**Cessna Drive
Variance of Use
Letter of Intent**

October 29, 2024

Vertex Consulting Services, LLC, on behalf of TTW Properties LLC, is respectfully submitting a variance of use application to allow for a “Commercial Vehicle Repair Garage” in the R-4, GA-O zone district. The property is located approximately one half of a mile southeast of the Judge Orr Road and Highway 24 Intersection, within Meadow Lake Airport. The proposed variance of use is compatible with the surrounding planned and existing development and is consistent with the Your El Paso Master Plan.

8242-8244 CESSNA DRIVE VARIANCE OF USE SITE PLAN

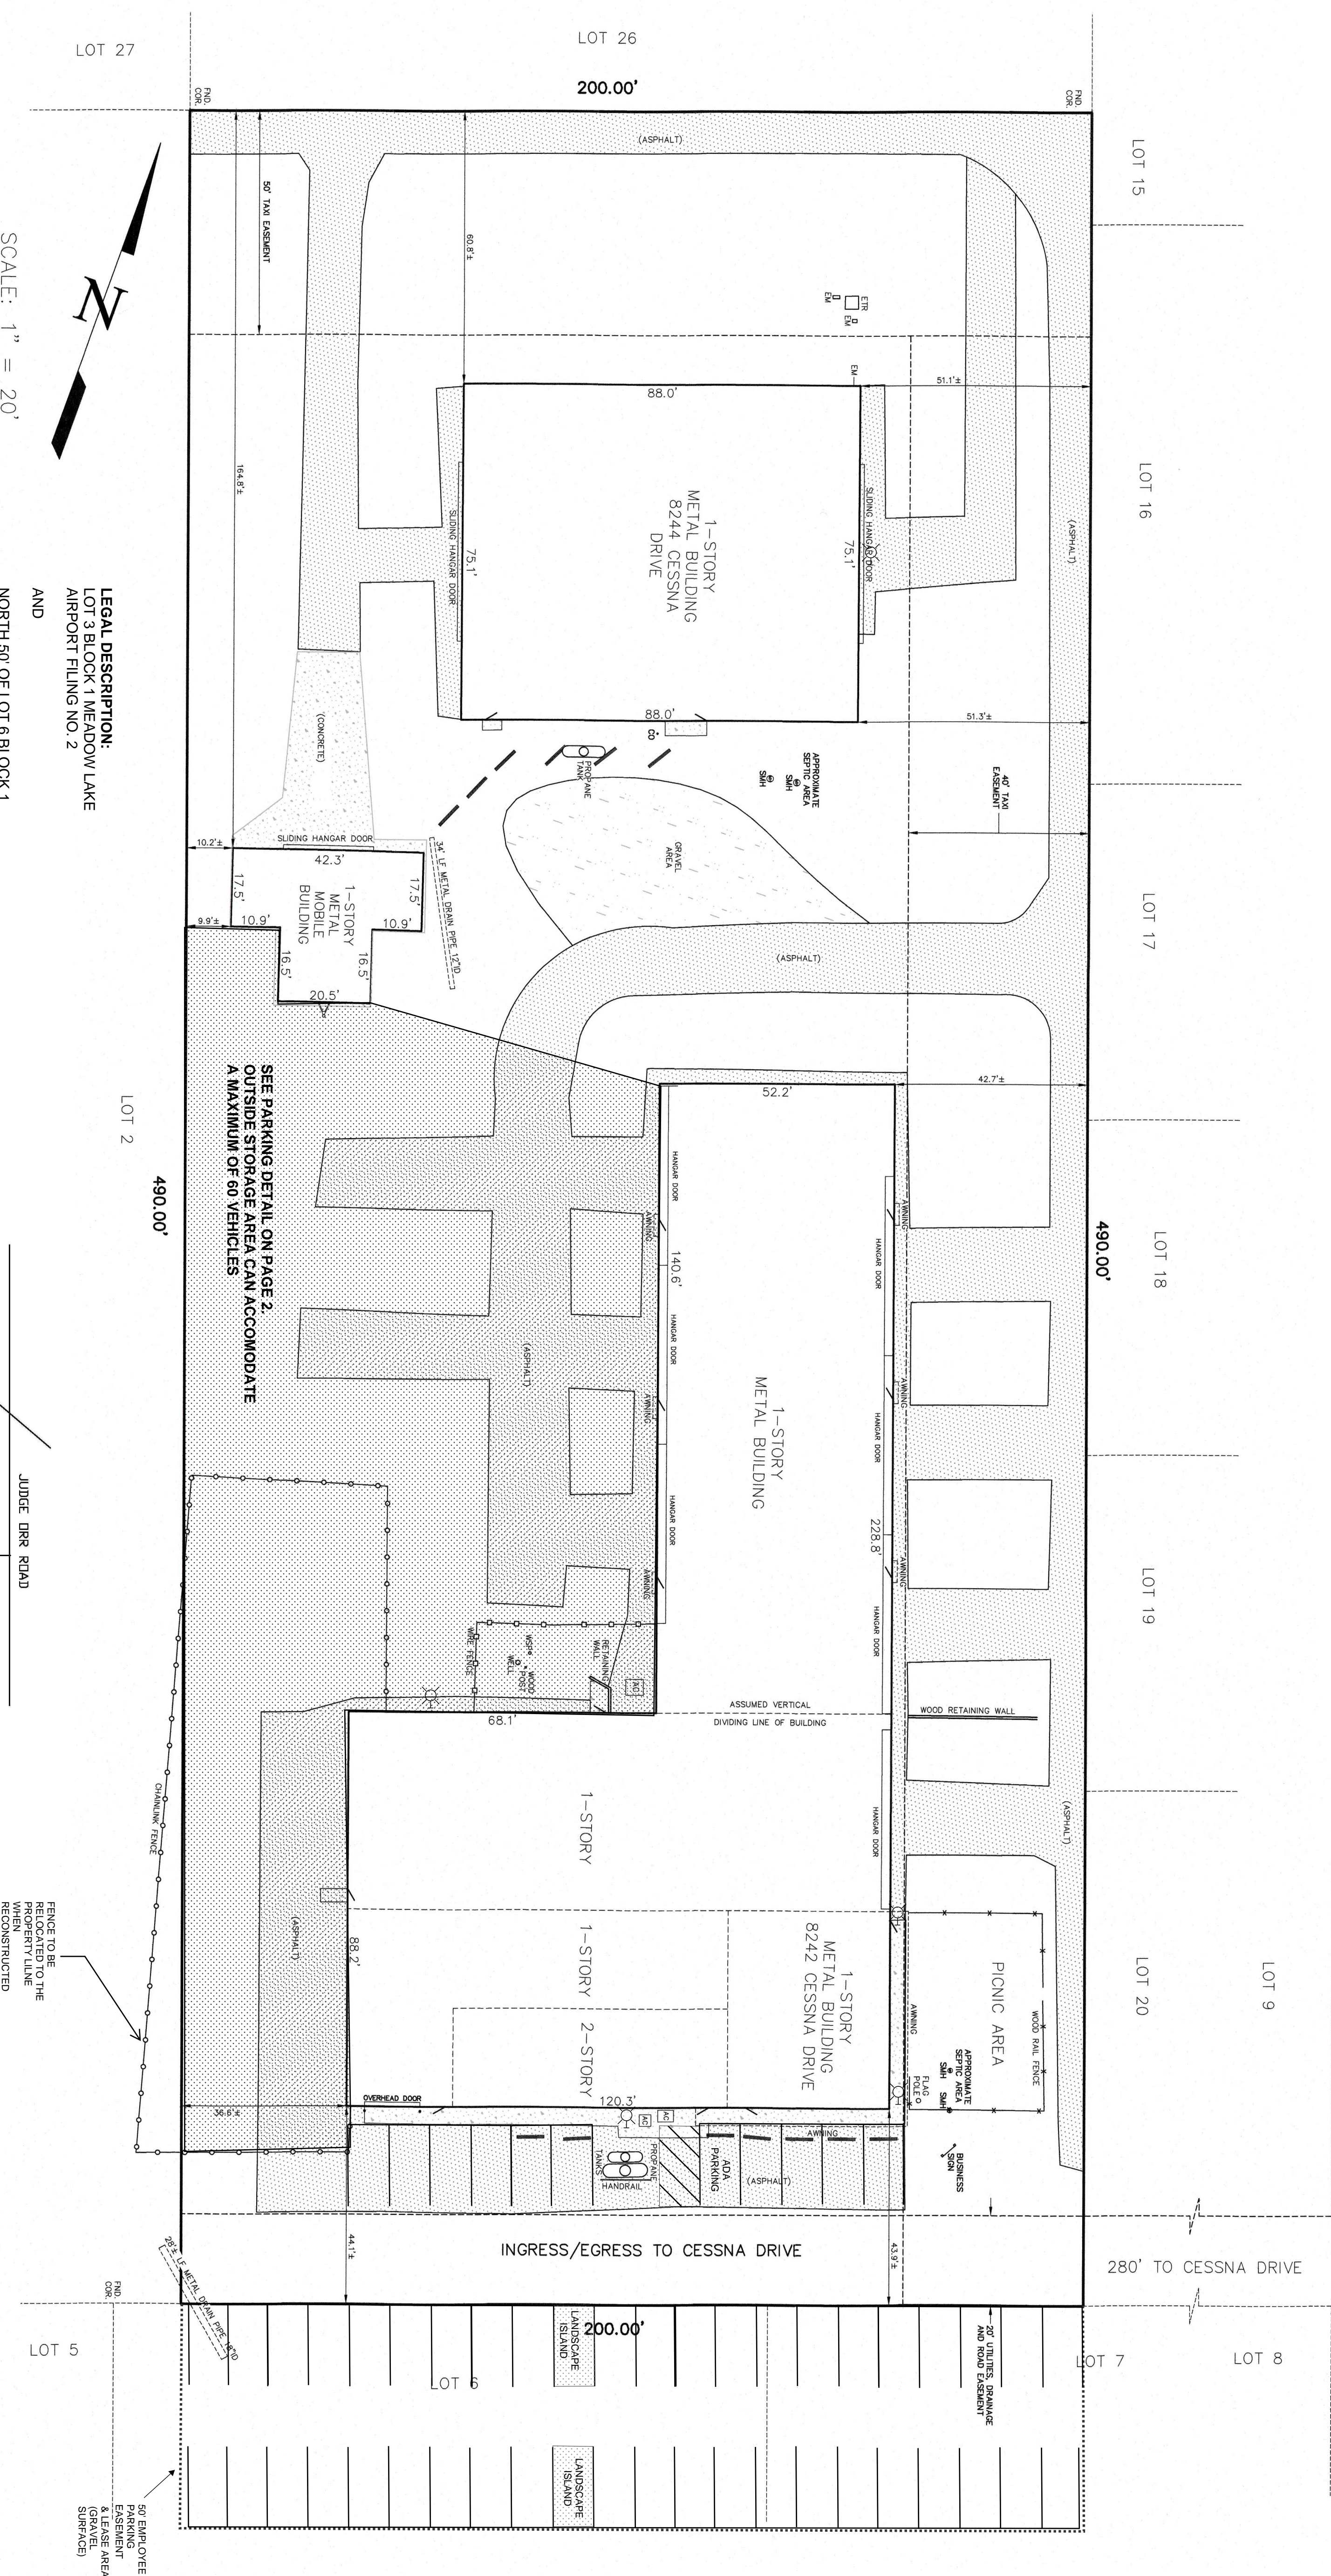
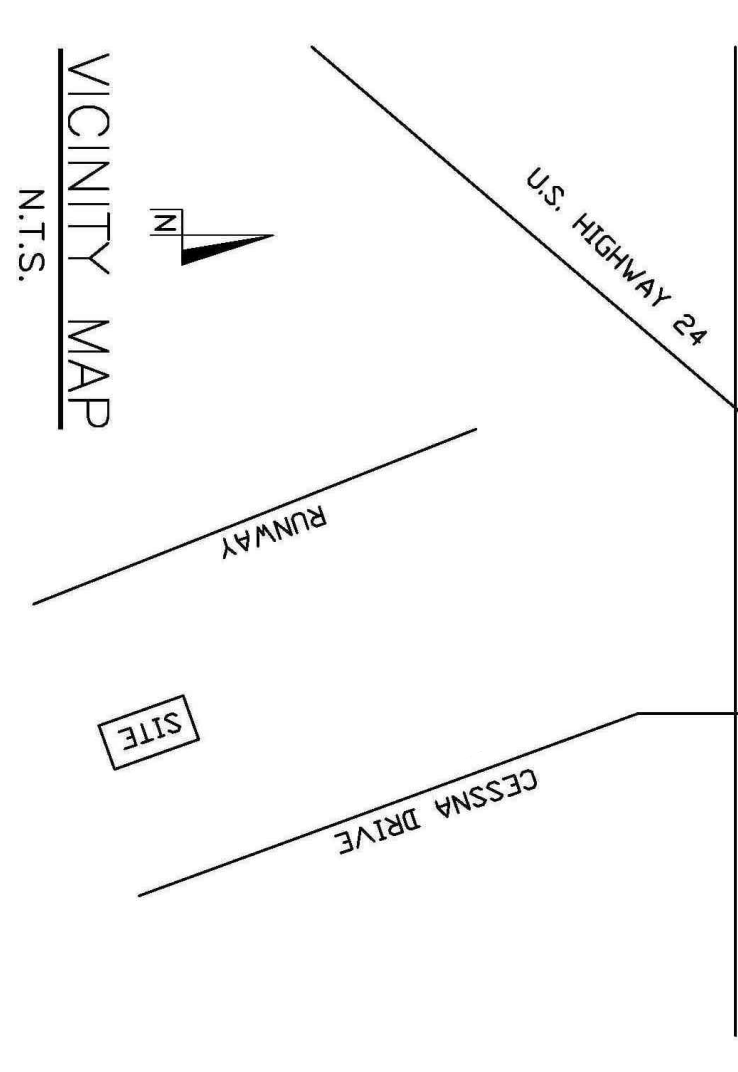
How was this max number derived? Why not less as property appears to be at max capacity with need for parking agreement on adjacent property?

Approximately 1-3 vehicles are dropped off every 2 weeks. Typically, when a vehicle is dropped off the same agency representative picks up another completed vehicle (e.g. Sherriff Deputy drops off a Tahoe needing updating and picks up an upgraded Tahoe for El Paso County Sherriff). It takes several weeks to customize each vehicle per the entities requests, resulting in numerous vehicles being stored onsite awaiting repair. The applicant has placed a condition on the site plan limiting the total number of vehicles being stored onsite to 40, and limited to those areas depicted.

The Land Development Code requires one parking space per employee plus 3 spaces per bay or stall. There will be a maximum of 24 employees total, not just on any given shift, and 8 bays. A parking easement has been provided for employee parking on the adjacent lot. The site plan depicts 55 parking spaces.
